The Secretary
NSW Department of Planning, Industry and Environment

29 May 2020

I refer to the Department's below email of 27 April 2020 regarding the notice of exhibition of the Environmental Impact Statement (EIS) for State Significant Development SSD-10431 at Moorebank Avenue, Moorebank (Lot 1 DP 1197707 and Lot 100 DP1049508) in the Liverpool City Local Government Area for the Moorebank Intermodal Precinct West - Stage 3 being the establishment of a works compound in the southern portion of the MPW site, associated ancillary works, subdivision of the MPW site into 9 allotments and the importation of clean fill material. Submissions needed to be made to the Department by 27 May 2020. I apologise for the late submission but trust that Endeavour Energy's recommendations and comments will still be considered.

STAGED PLAN OF PROPOSED SUBDIVISION OF LOT 1 DP1197707 AND LOT 100 DP1049508

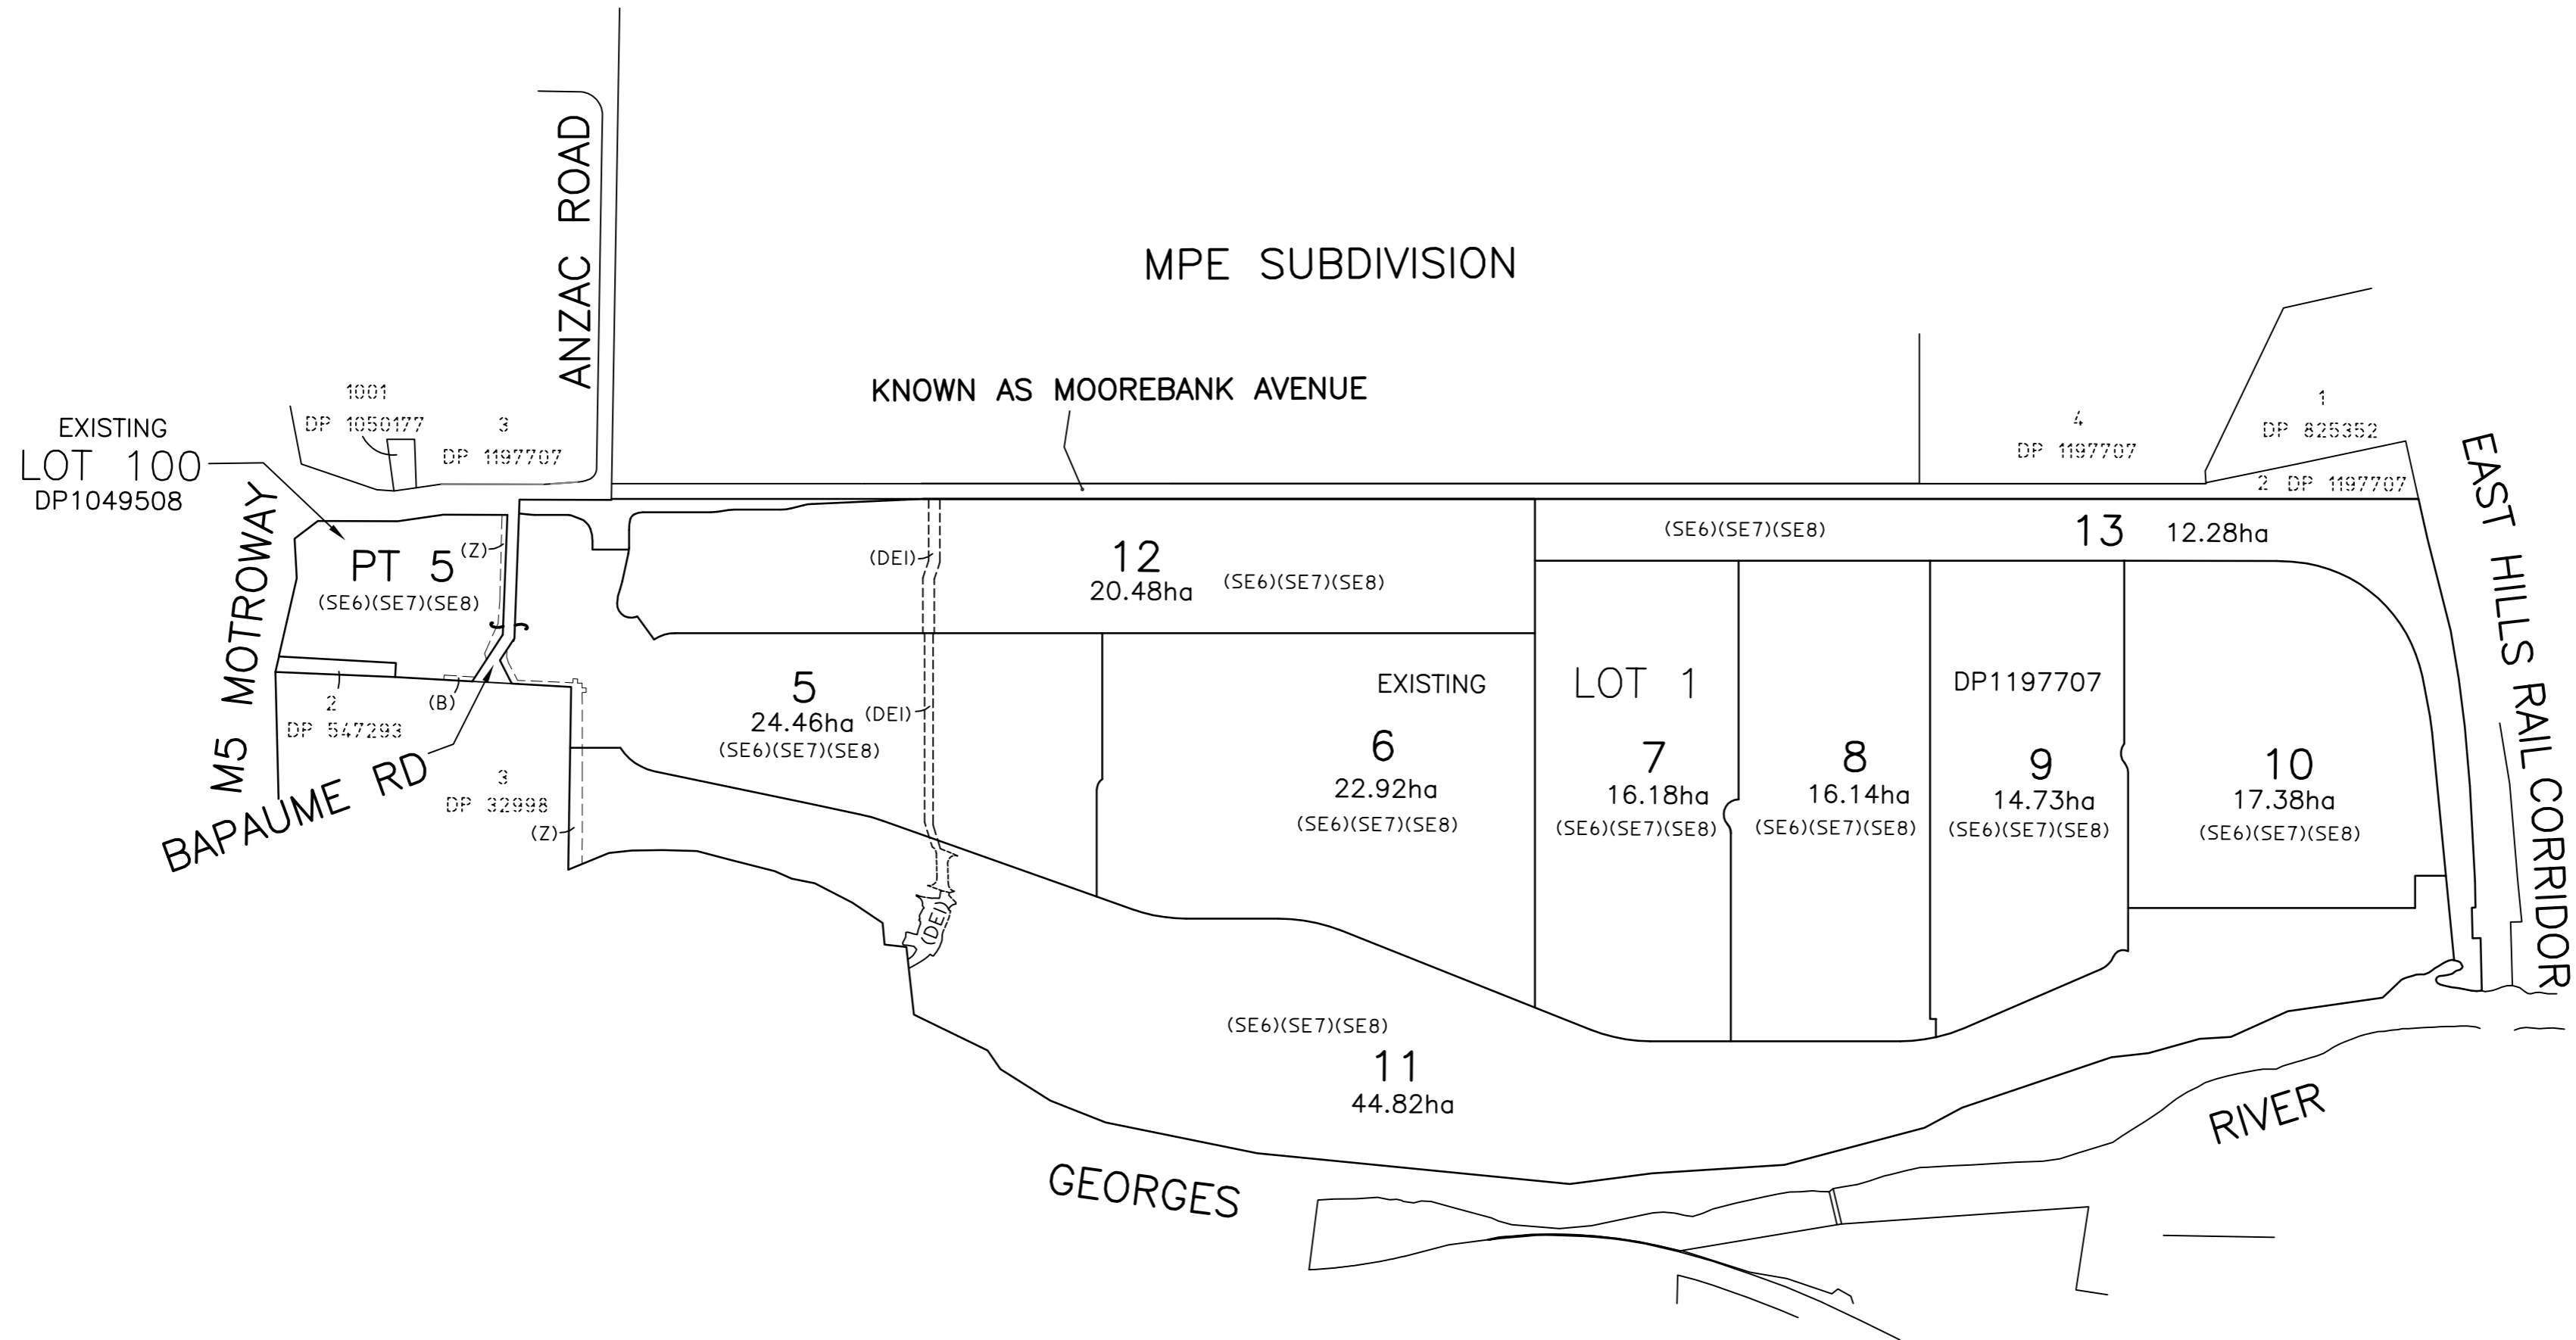
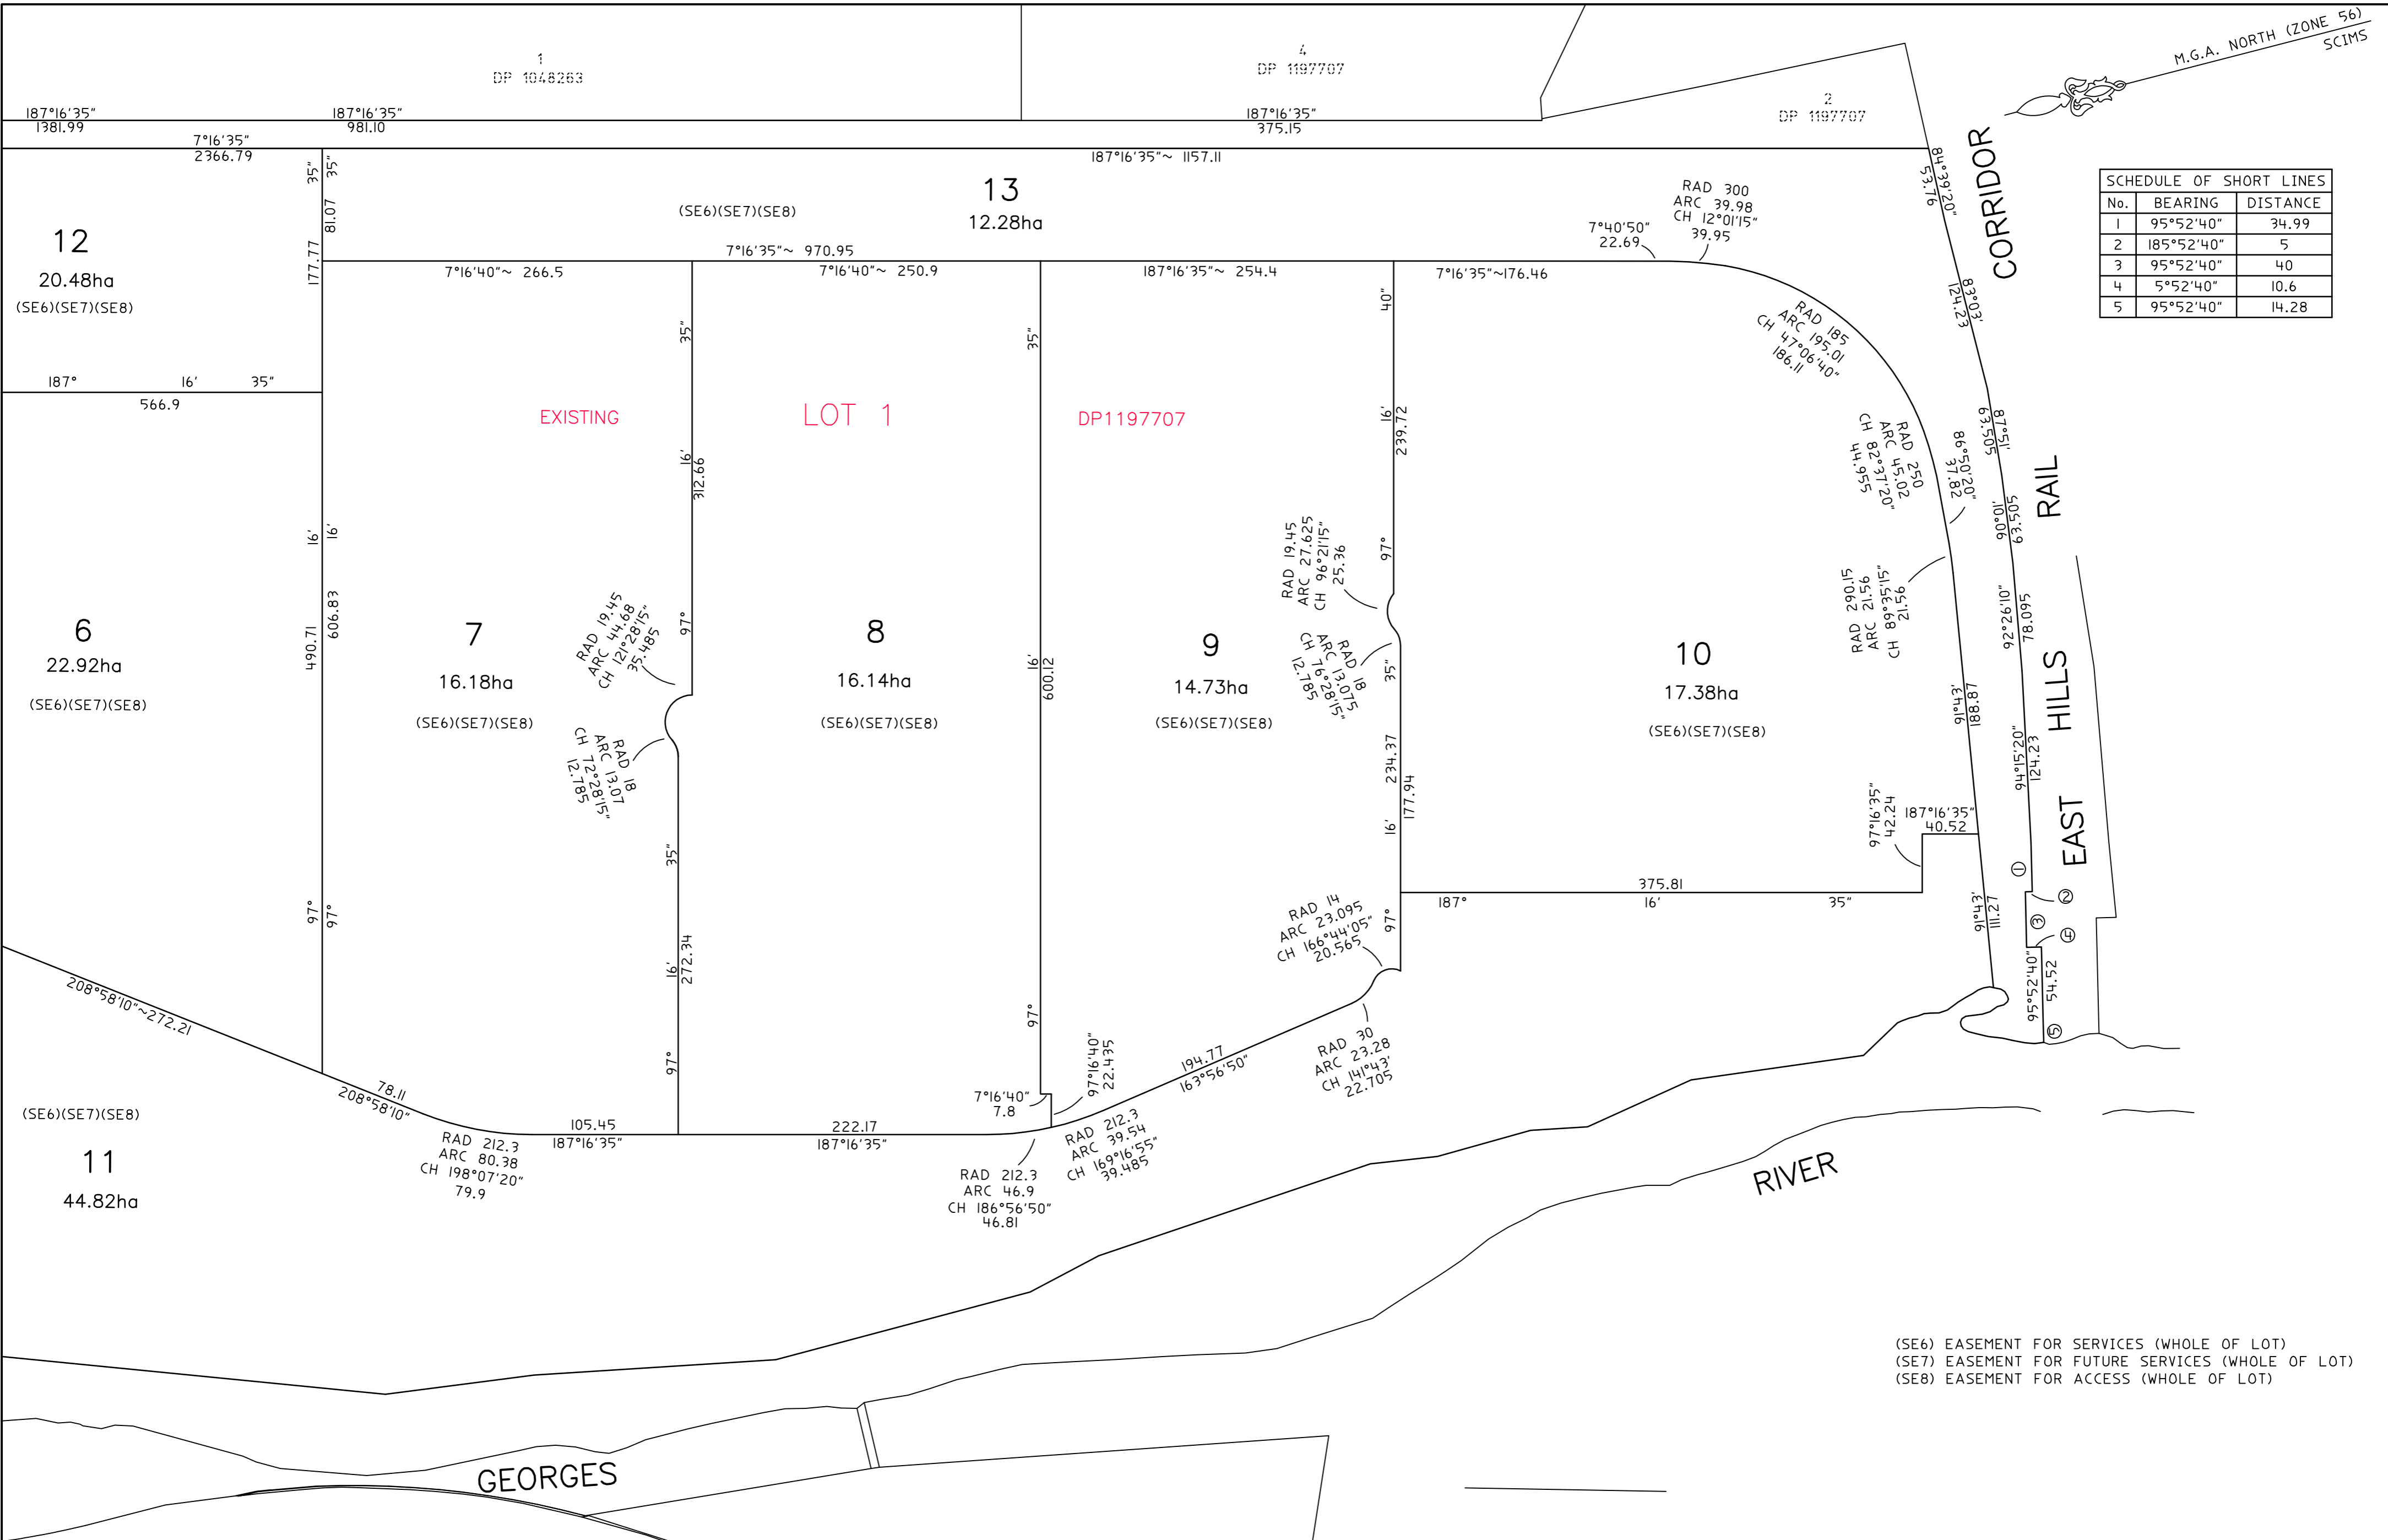
- Easement to the northern part with frontage to Bapaume Road for 11 kV high voltage and 33 kV ('Out of Service') high voltage overhead power lines ie. being the continuation of those on Lot 100 DP1049508. The 11 kV high voltage overhead power lines appear to be partially outside the easement where they cross Bapaume Road.

Where a subdivision results in the incorporation of Endeavour Energy's easement into a different or multiple lots, the easements, rights and restrictions, covenants etc. be retained over the effected lots and in accordance with the requirements of NSW Land Registry Services (LRS).

Accordingly Endeavour Energy's recommendation is that whenever reasonably possible, easements be entirely incorporated into public reserves and not burden private lots. Endeavour Energy's preference is to have continuity of its easements over the most direct and practicable route affecting the least number of lots as possible.
